Recommendation Report for Planning Permission for Works or Extension to a Dwelling

REF NO: BR/63/21/HH

LOCATION: 2A Merchant Street
Bognor Regis
PO21 1QH

PROPOSAL: First floor rear extension

Proposed Rear Extension Plans and Elevations Planning Date February 2021 Scale 1:50

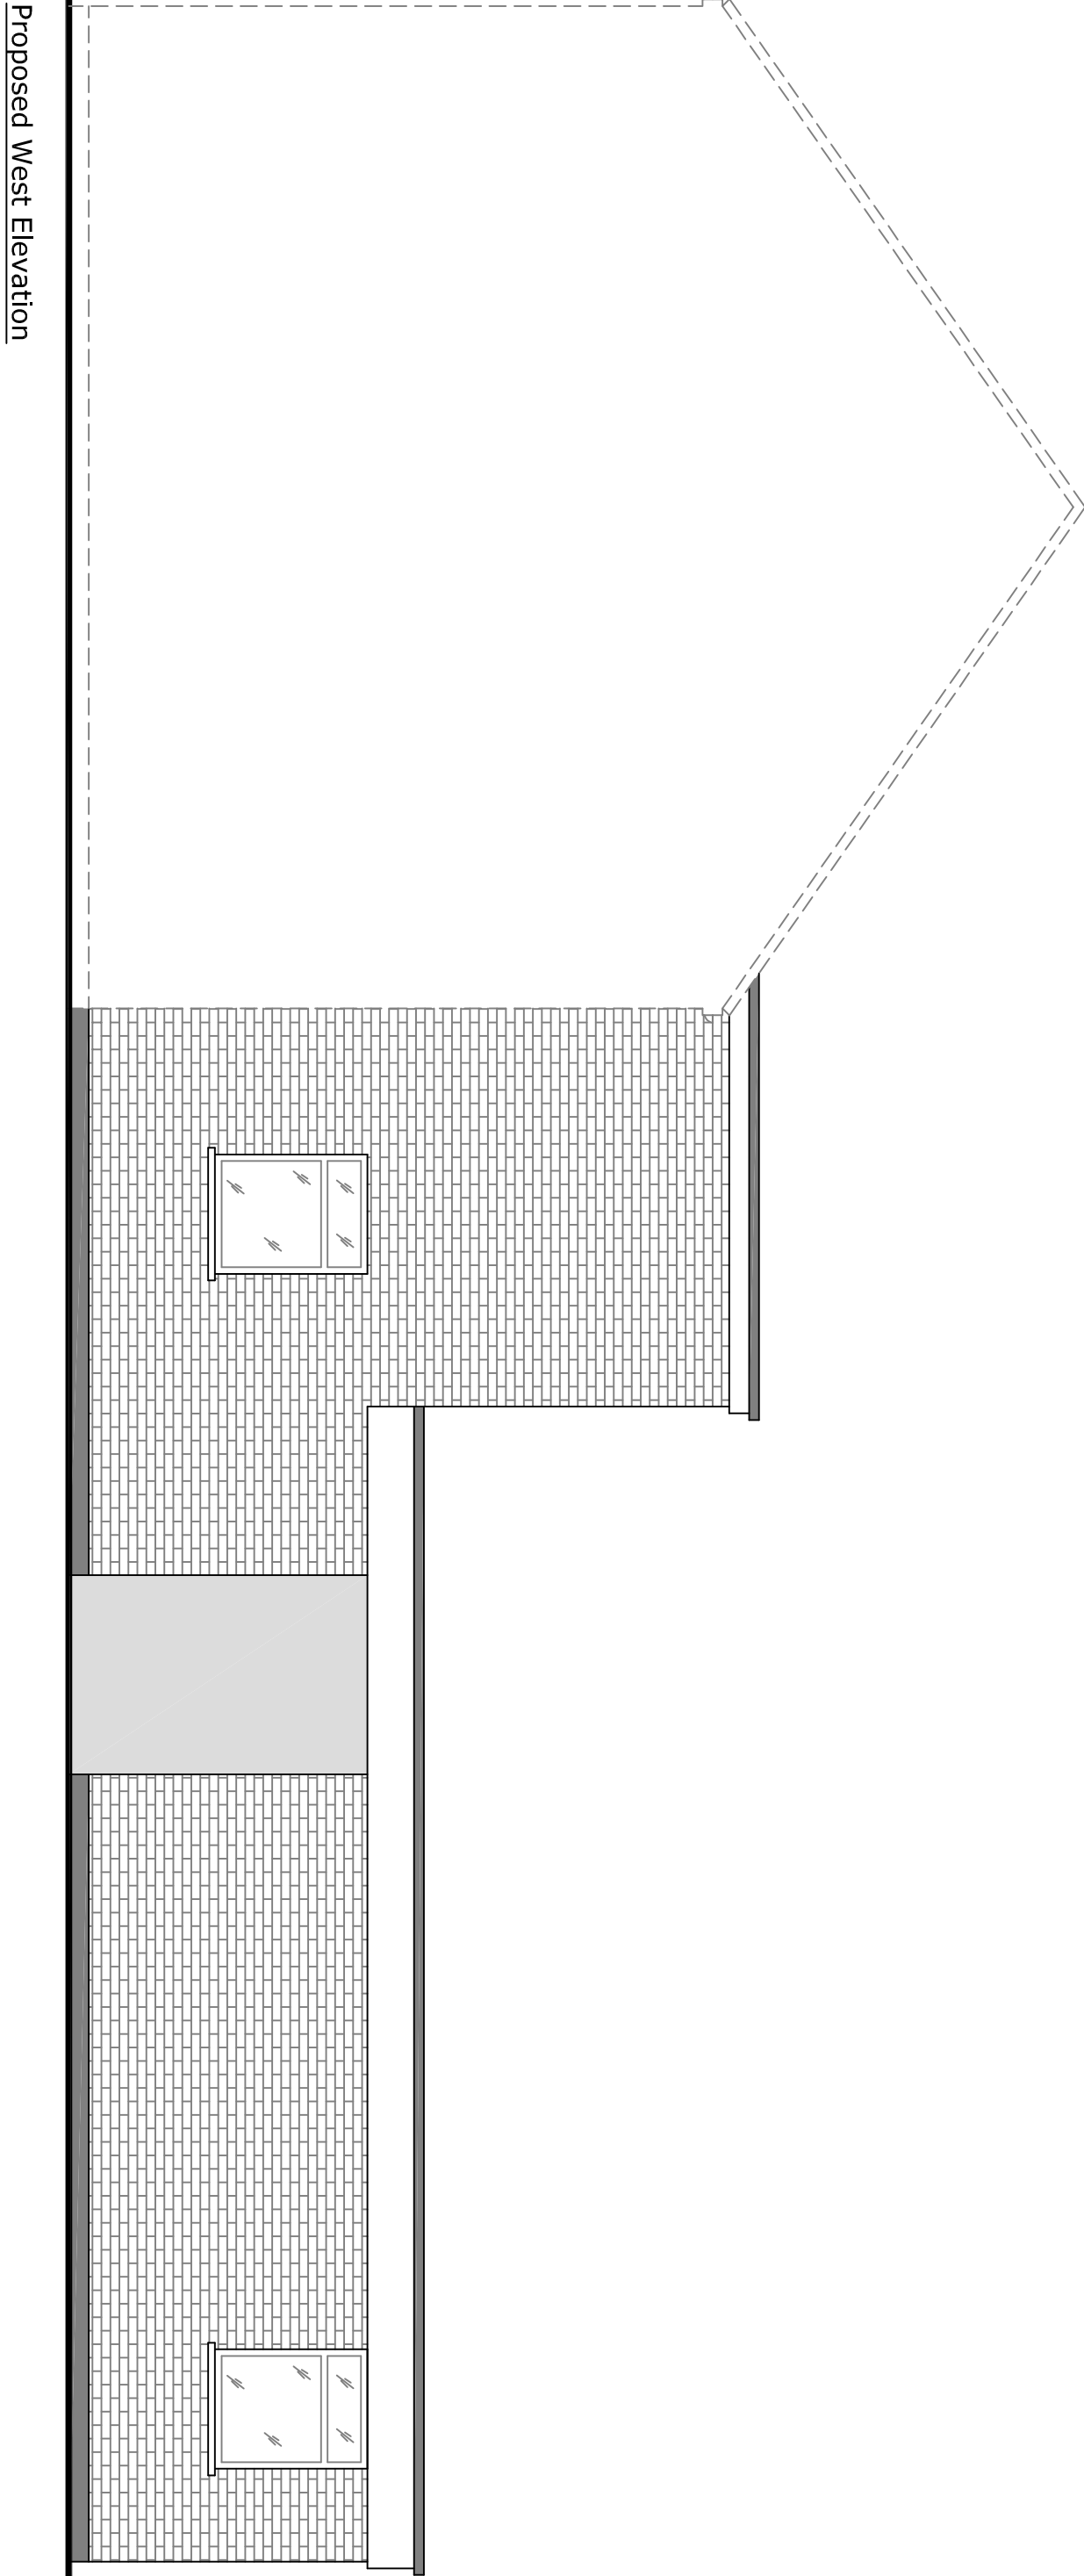
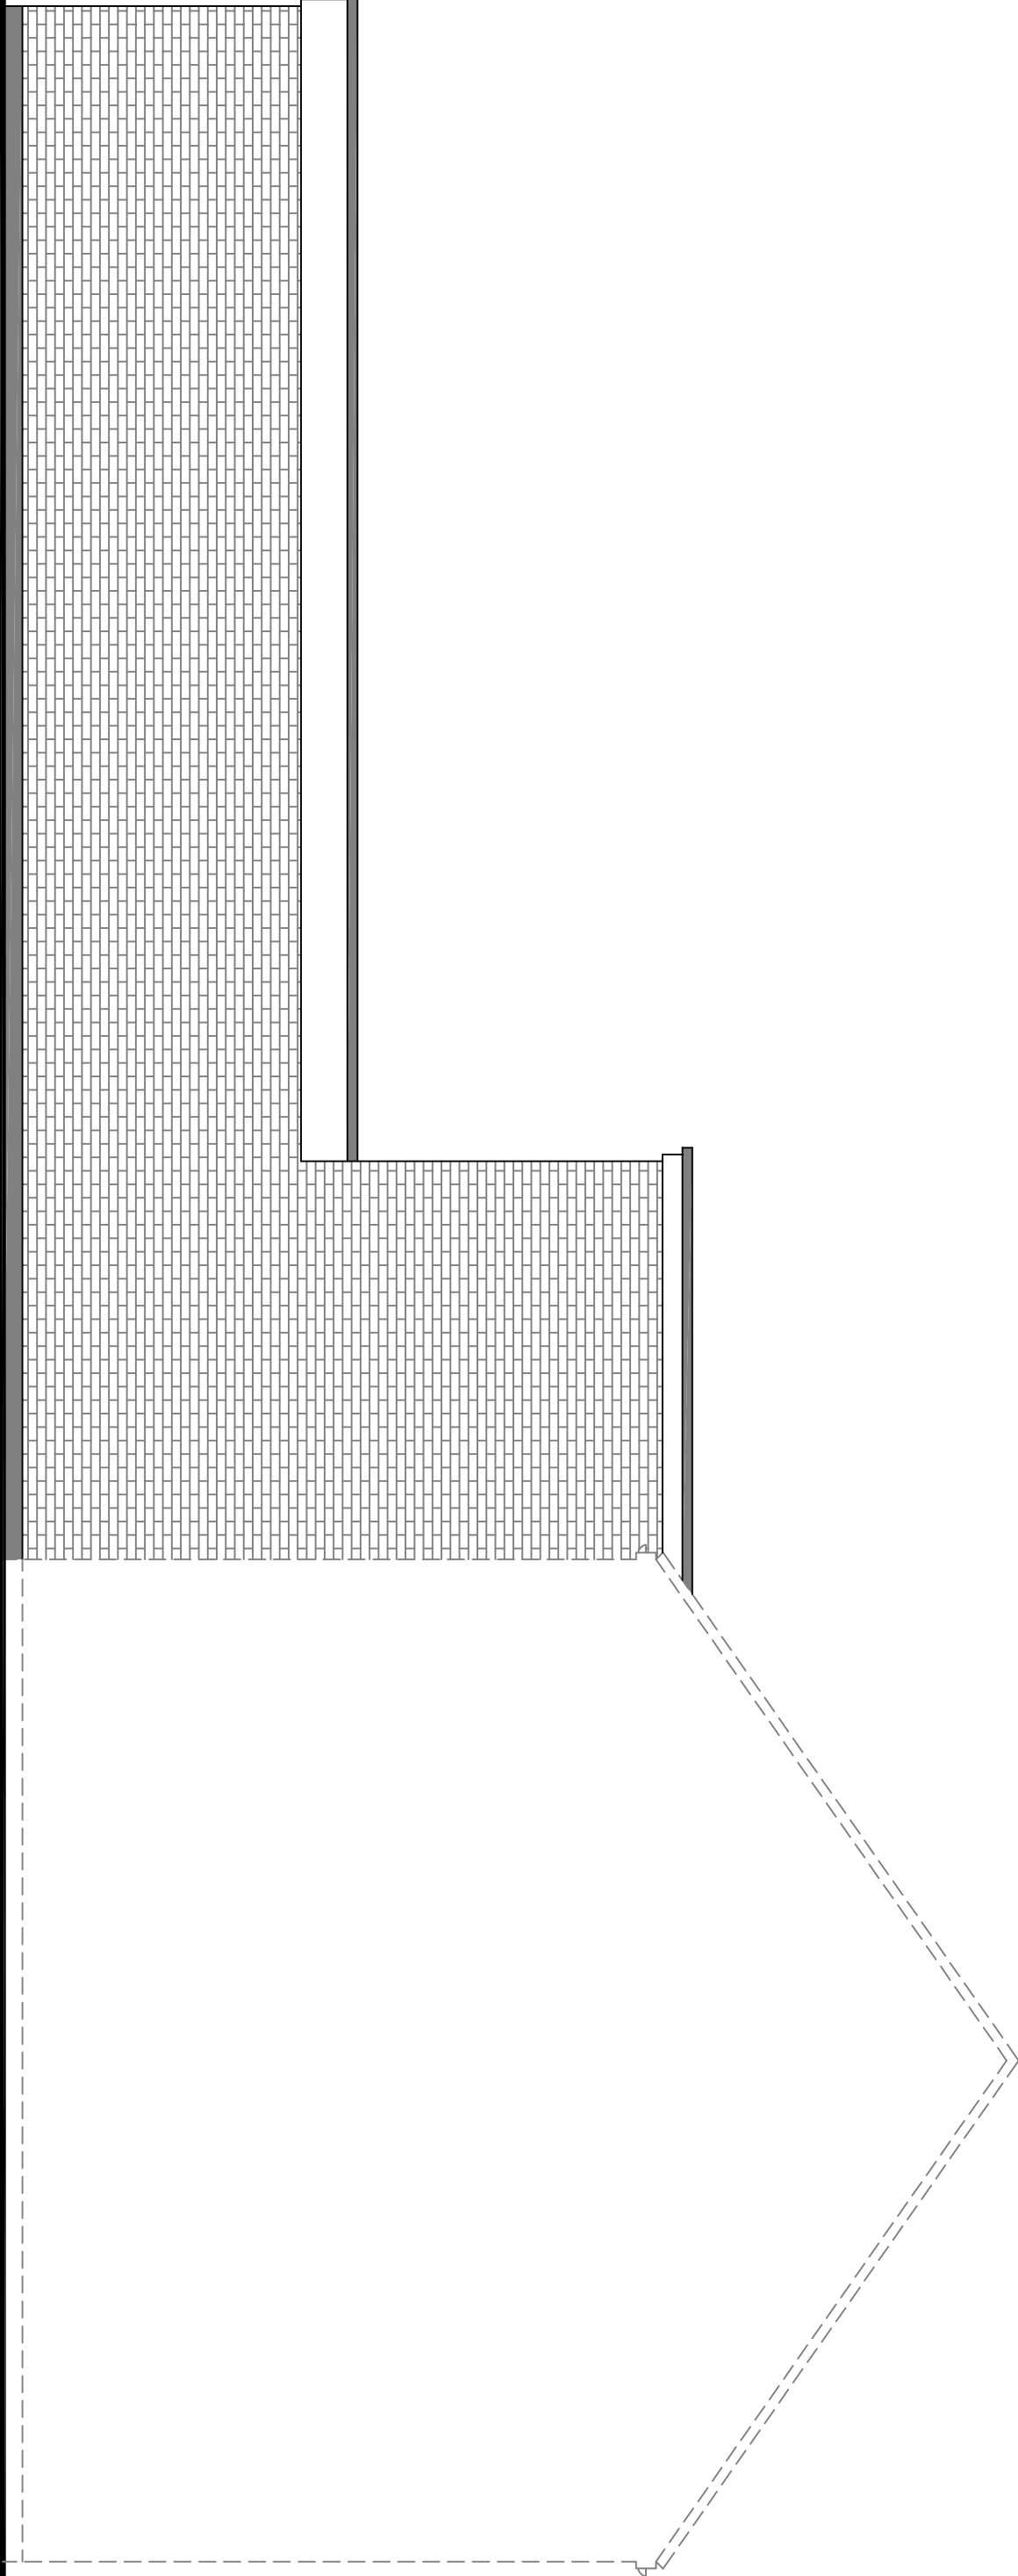
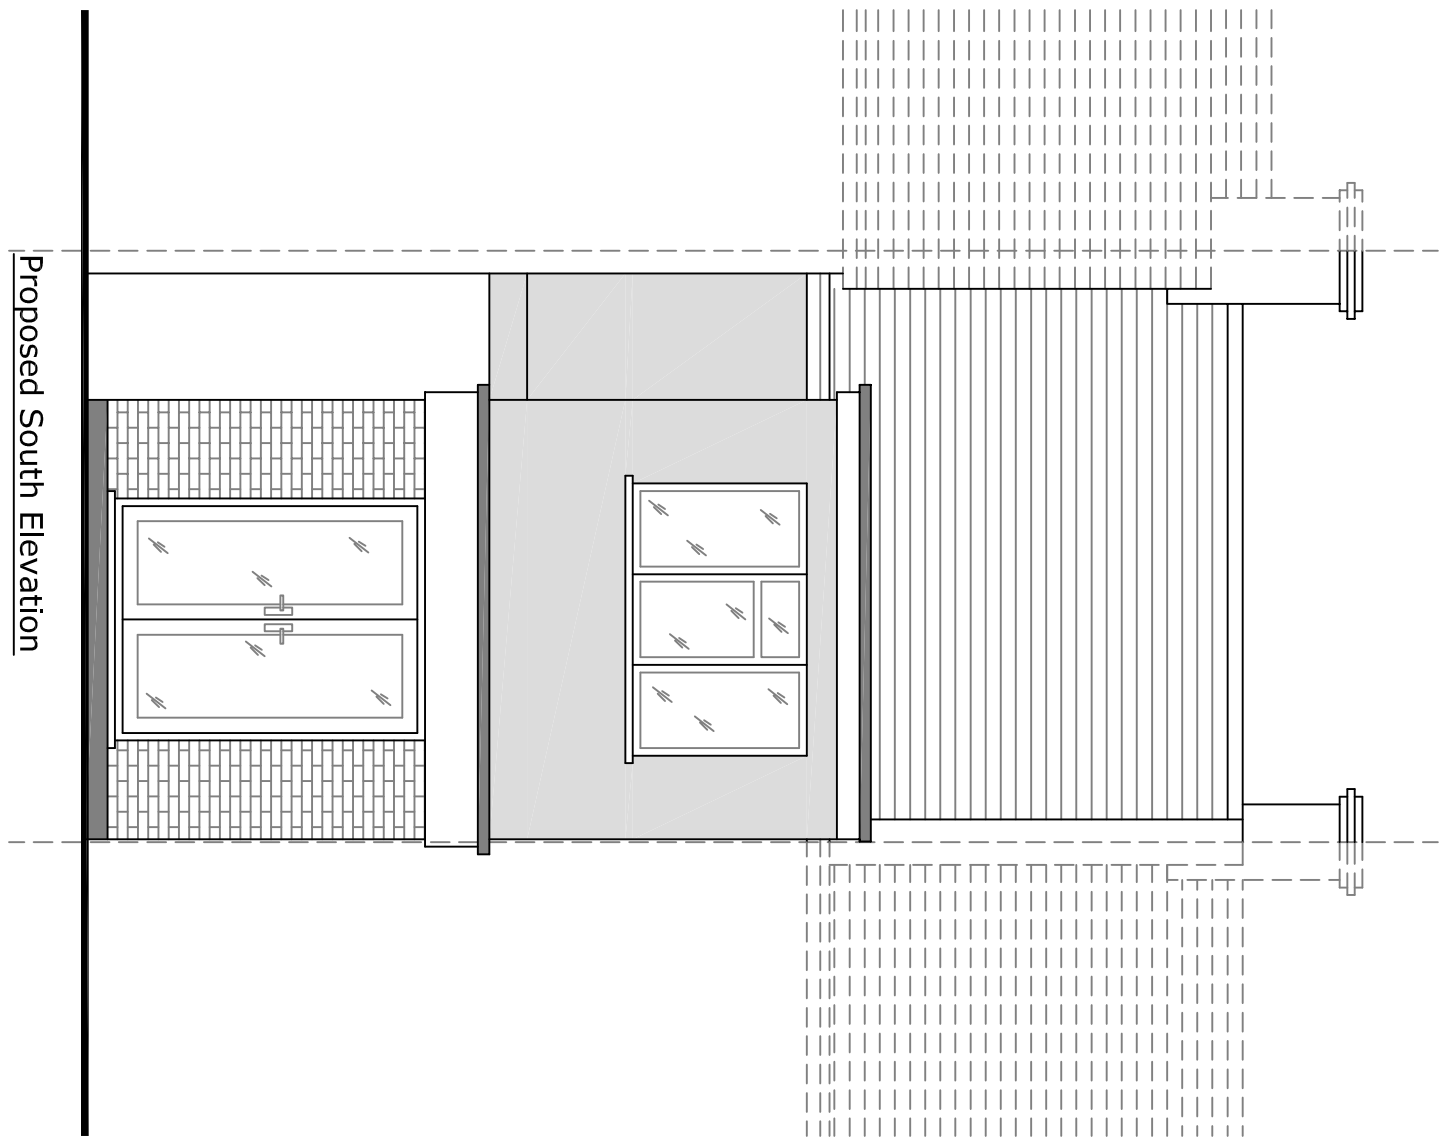
Due to the siting of the development at the rear, there will not be views of the development from the public realm.

The development appear well integrated with the host dwelling, and subservient to its built form. Resultant of these factors, the proposed development is not considered to result in any significantly harmful impact upon the character of the host dwelling or its locality.

Furthermore, through section M of the Arun Design Guide which refers to householder extensions. Extensions should respond to and complement the existing character and appearance of the building and wider townscape in terms of scale, massing. It is considered this is achieved, with the addition appearing well integrated and sympathetic in design to the host dwelling.

Proposed First Floor Plan

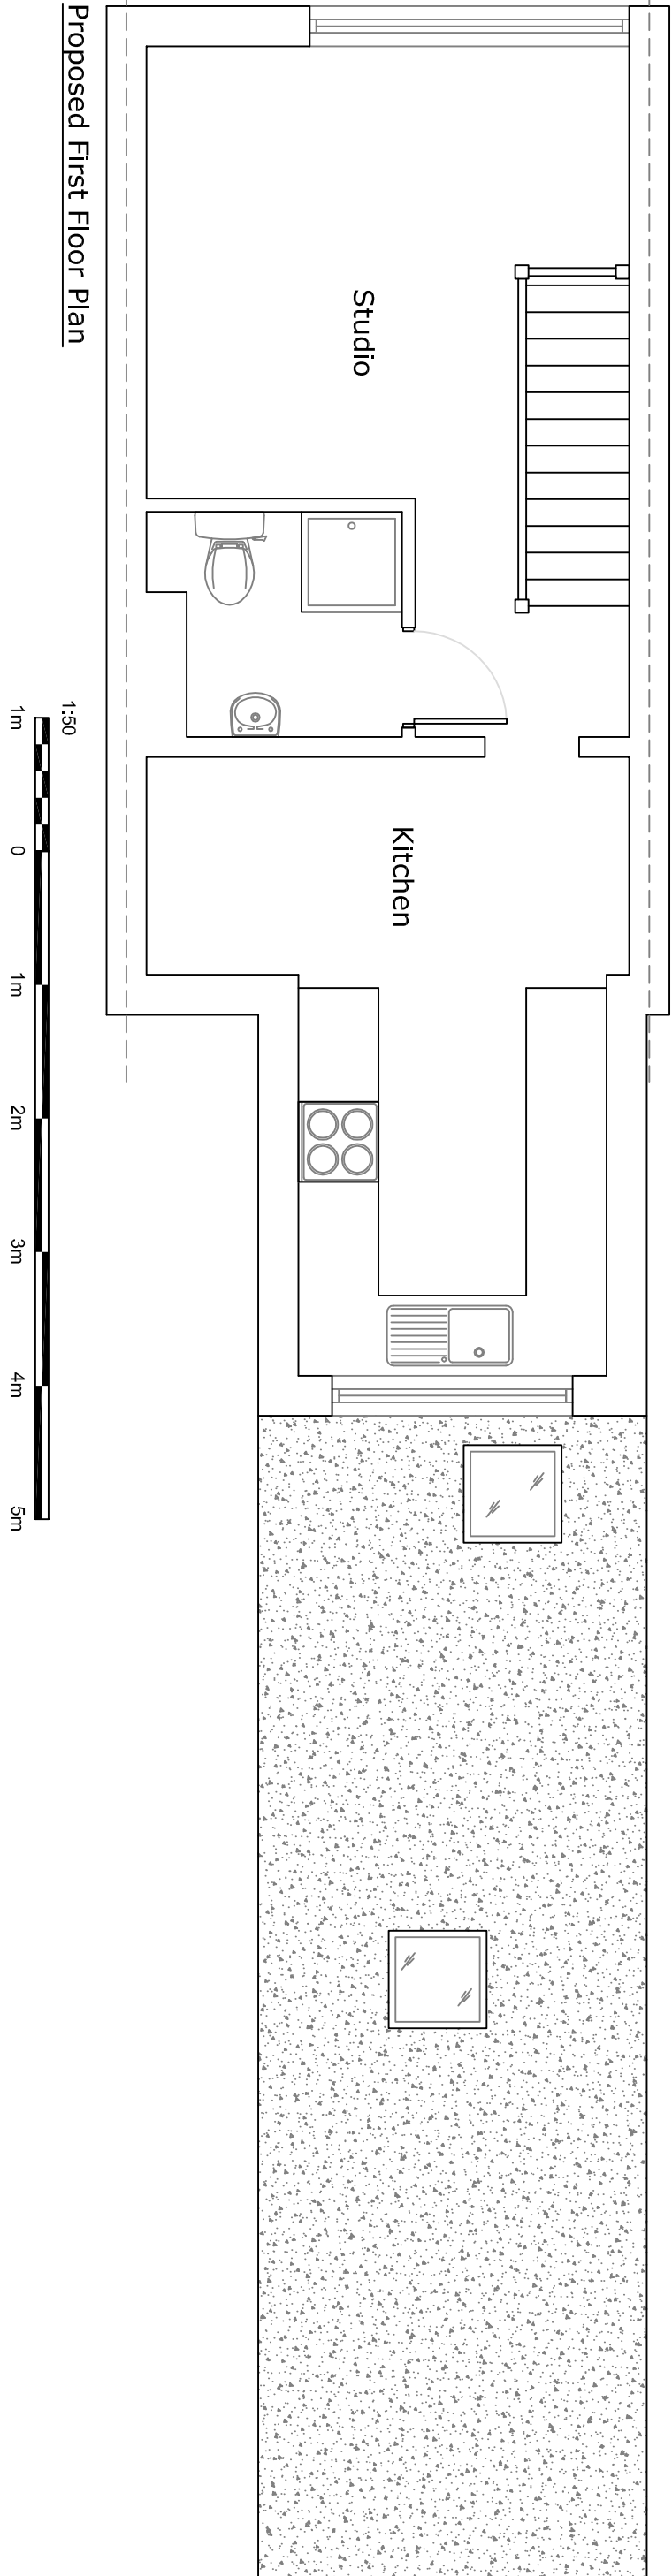
The development has a significant impact on the residential amenities of neighbouring dwelling. The proposed construction would be located on the boundary causing overshadowing and an unacceptable overbearing impact. This is due to the window of the neighbouring dwelling being close to the boundary which would have all light blocked out.

The new building would fail to meet the 25 degree rule when measured from the rear of 2 Merchant Street contrary to Part M of the Arun Design Guide.

There is 11.8m from the rear boundary and 0.85m from the northern boundary. The proposed window is sited on the rear elevation not gaining a view of any neighbouring dwellings. As the proposal is on the first floor and development of this scale being 2.9m in depth mitigates any potential for loss of privacy however, the extension is deemed to break the 45 degree ruling as the extension runs along the boundary. The neighbouring property has a window located close to the boundary and the proposed development would then cast a shadow over said opening. The extension would impact on the enjoyment of the neighbouring property and thus is not considered to not be in accordance with D DM1(3) and D DM4(c) of the Arun Local Plan.

- 1 The first floor extension, by virtue of its siting, size and proximity to the boundary will have an unacceptable overbearing impact upon the neighbouring property, 2 Merchant Street, in conflict with policies D DM1 and D DM4 of the Arun Local Plan as well as Section M of the Arun Design Guide.
